Air Quality Specialist Response

17 June 2016

RE: Response to Agency Submissions for Rix's Creek Continuation of Mining Project

Figure B-1: Sensitive receptor locations assessed in this study

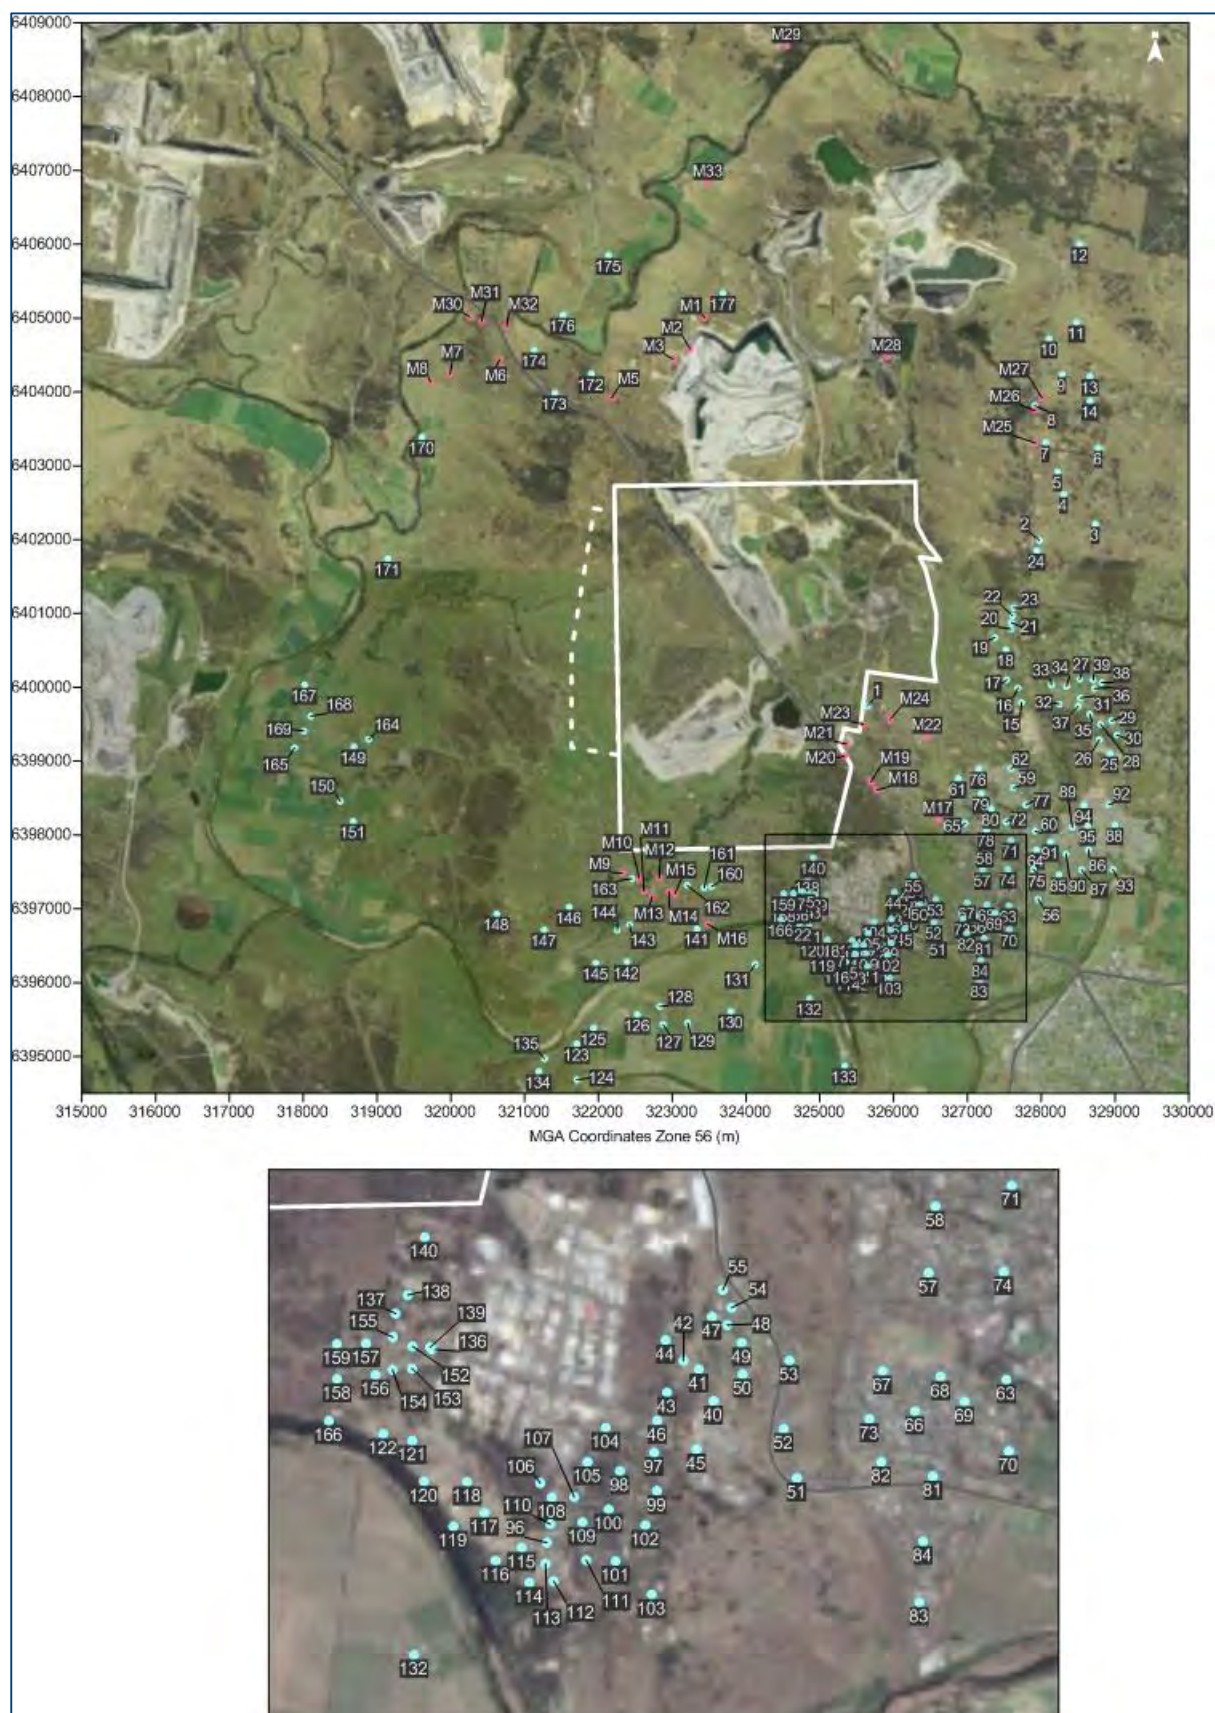
A clarification of the AQA has been identified with regards to the sensitive receptor locations presented in Appendix B of the AQA. In Figure B-1 of Appendix B of the AQA, the mine owned receptors labelled as M5 to M33 are incorrect and should be labelled from M4 to M32.
